WEST SUSSEX COUNTY COUNCIL CONSULTATION

TO:	Arun District Council FAO: Mr K Roberts
FROM:	WSCC - Highways Authority
DATE:	3 September 2019
LOCATION:	Arundel Acre Arundel Road Angmering BN164EU
SUBJECT:	A/100/19/PL Change of use of land from agriculture for 3 No. travelling showpeople plots (Sui Generis) with associated storage barn, maintenance area, landscaping & infrastructure.
DATE OF SITE VISIT:	n/a
RECOMMENDATION:	Objection
S106 CONTRIBUTION TOTAL:	n/a

Access Junction with Visibility Splays

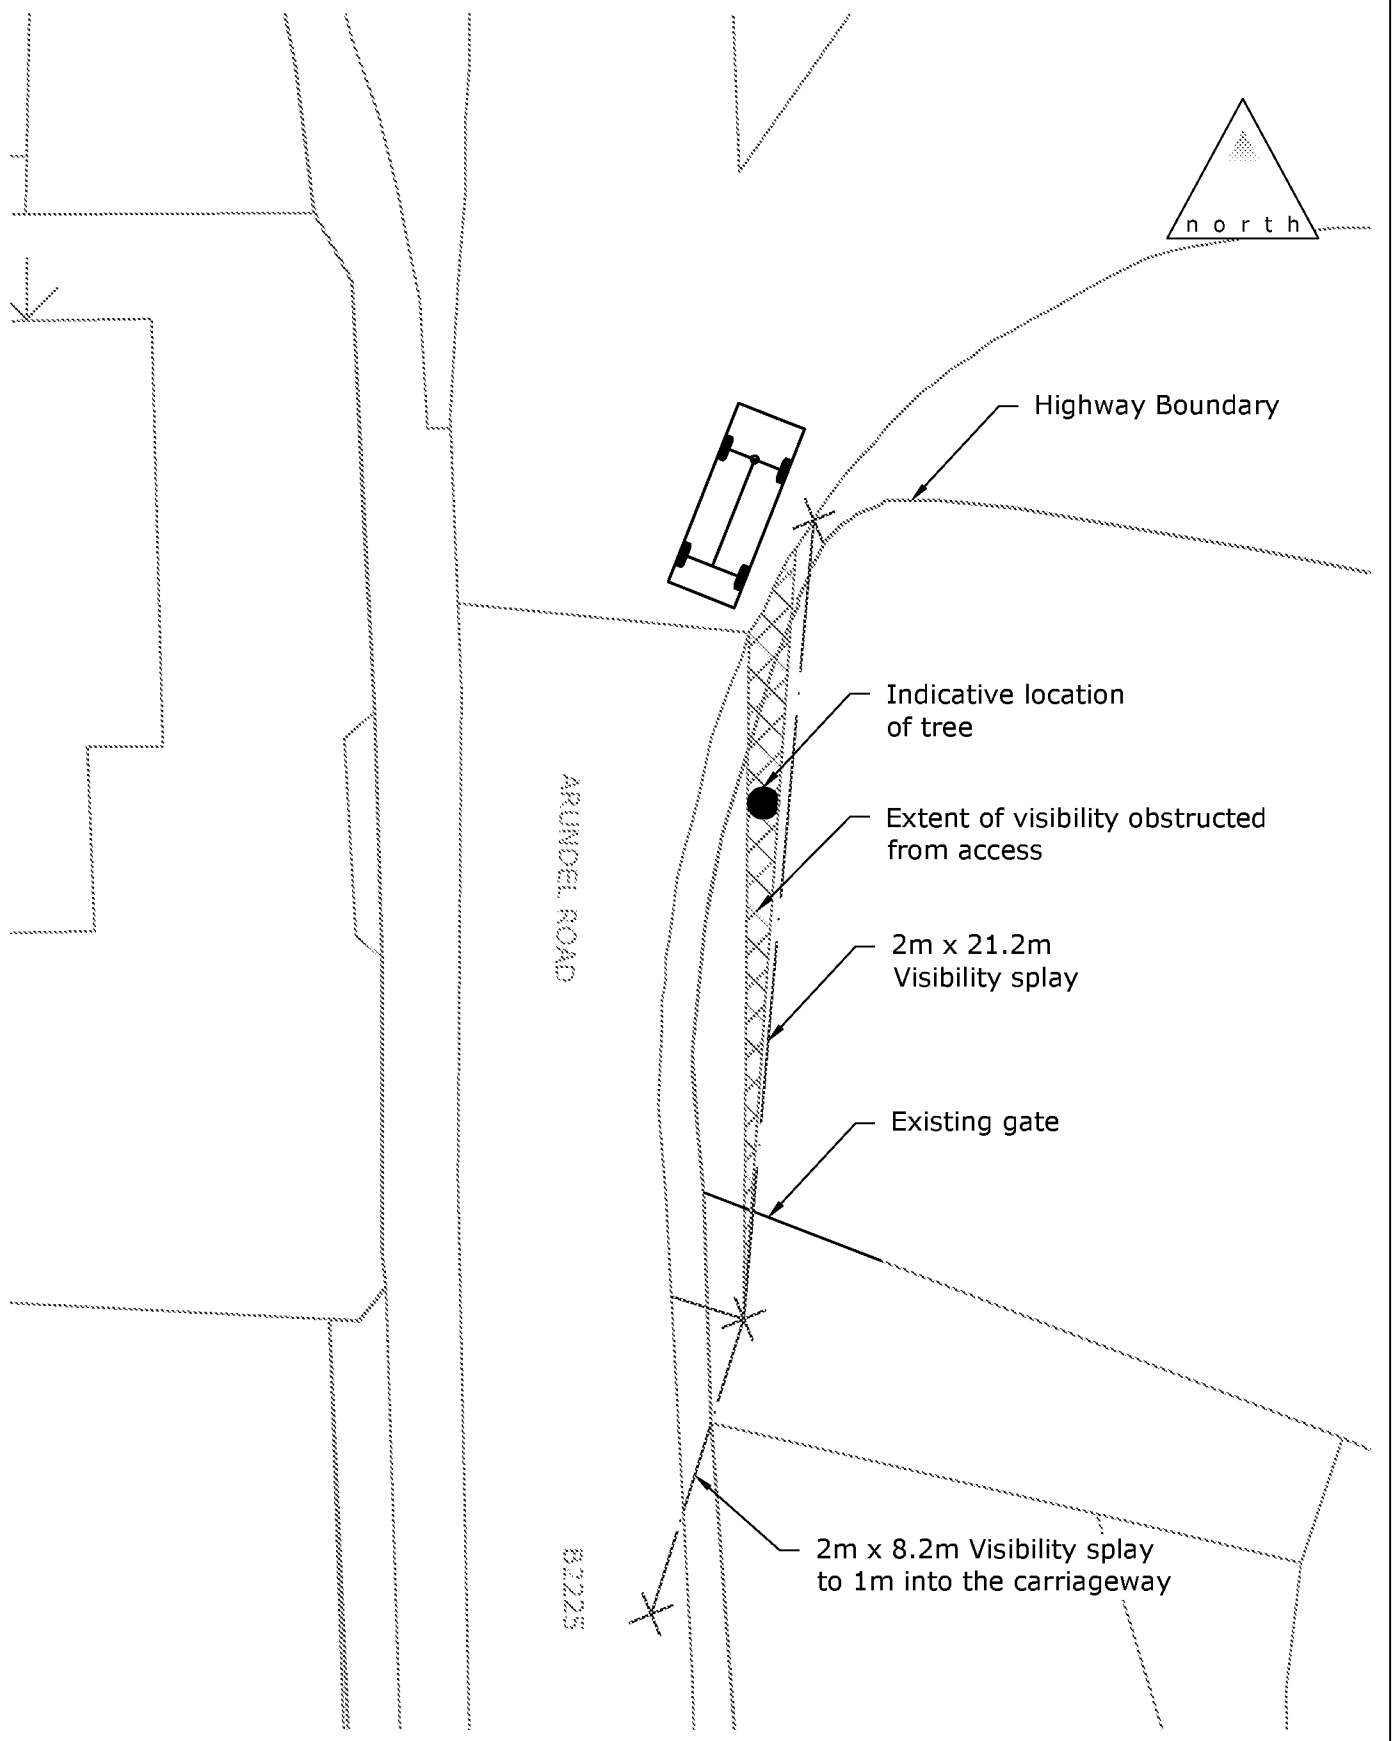
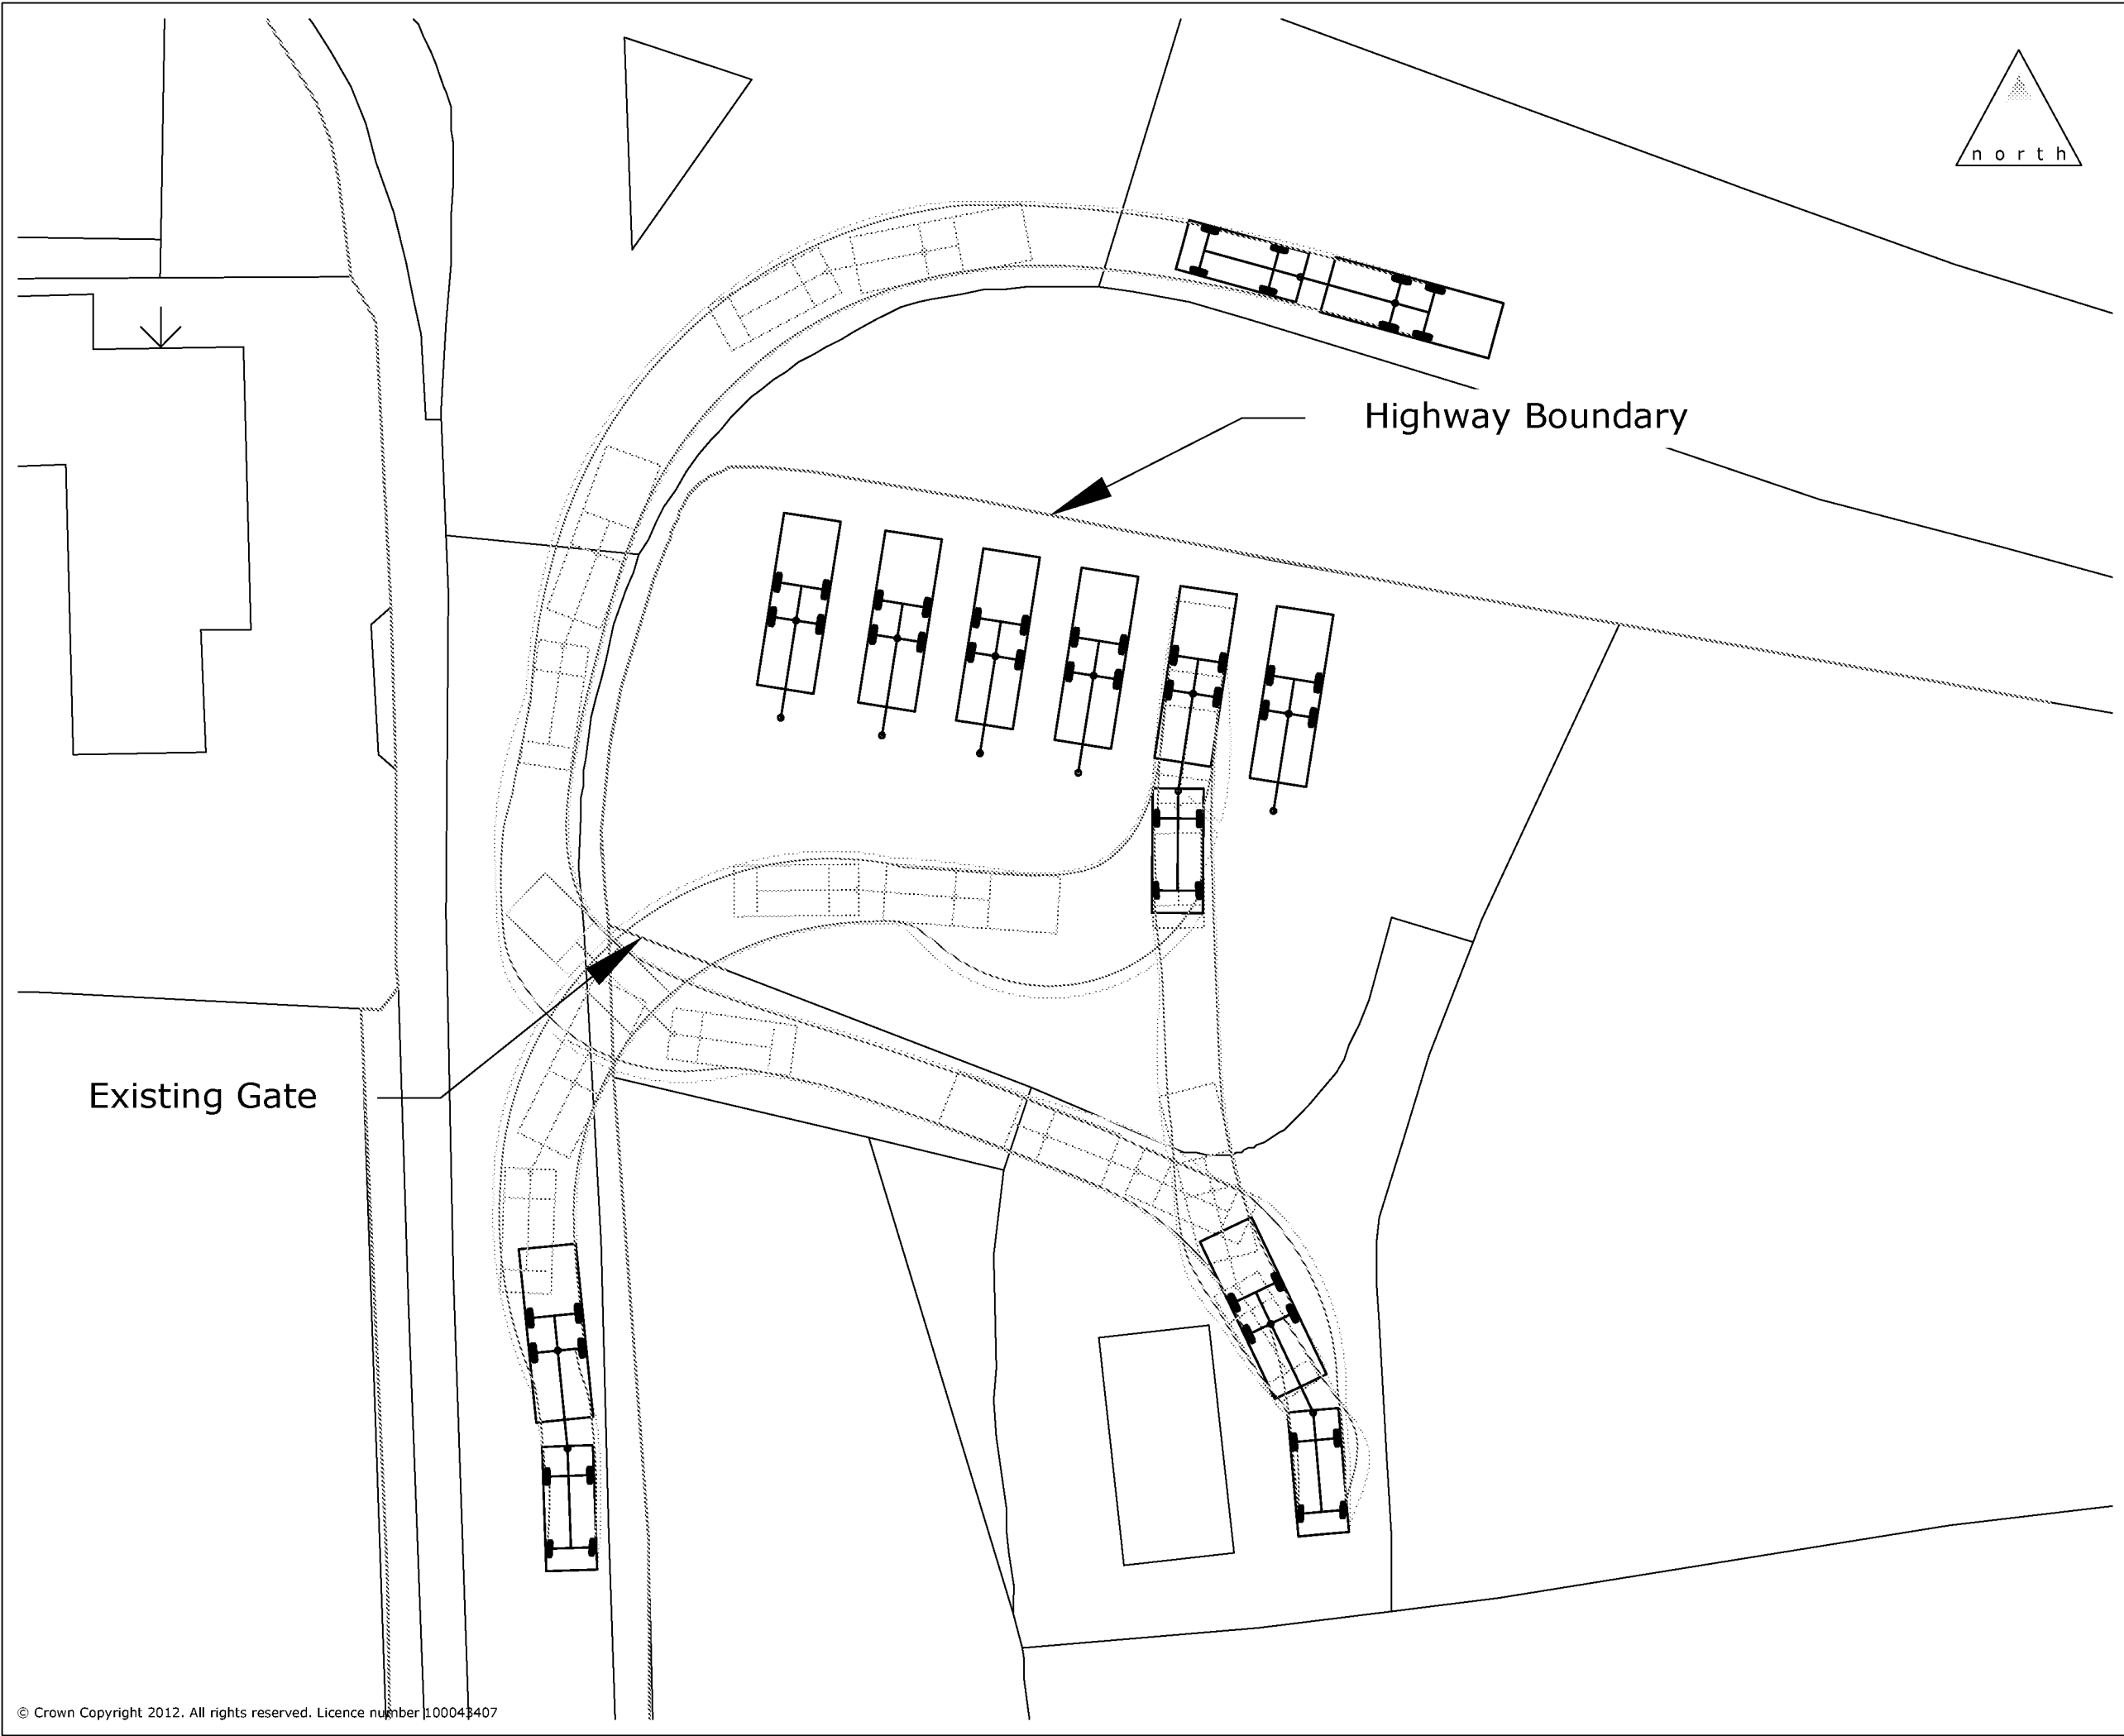
As per A/3/18/PL it was accepted that a visibility splay of 2.4 x 21 metres is achievable and would be considered an improvement against the existing situation, where visibility is extremely limited.

The LHA is satisfied that such a condition could be imposed to secure such an improvement, however the Local Planning Authority (LPA) would be advised that the formation of such a splay is going to have a significant impact upon the vegetation boundary in this location, and may require the removal of a mature tree.

Visibility Trailing Direction (South)

As previously assessed under A/111/17/PL & A/3/18/PL visibility in the trailing direction was extremely limited due to 3rd party land. The maximum available visibility was demonstrated as 2.0 x 8.2 metres, measured 1.0 metre into the carriageway. The LHA did not accept that a 2.0 metre 'X' distance should be used. Nevertheless this would only equate to the stopping sight distance of an approach speed of 7 mph as per Manual for Streets calculation coefficients.

No evidence, previously or as part of this application has been provided to demonstrate such visibility is suitable or that any significant improvements could be made.
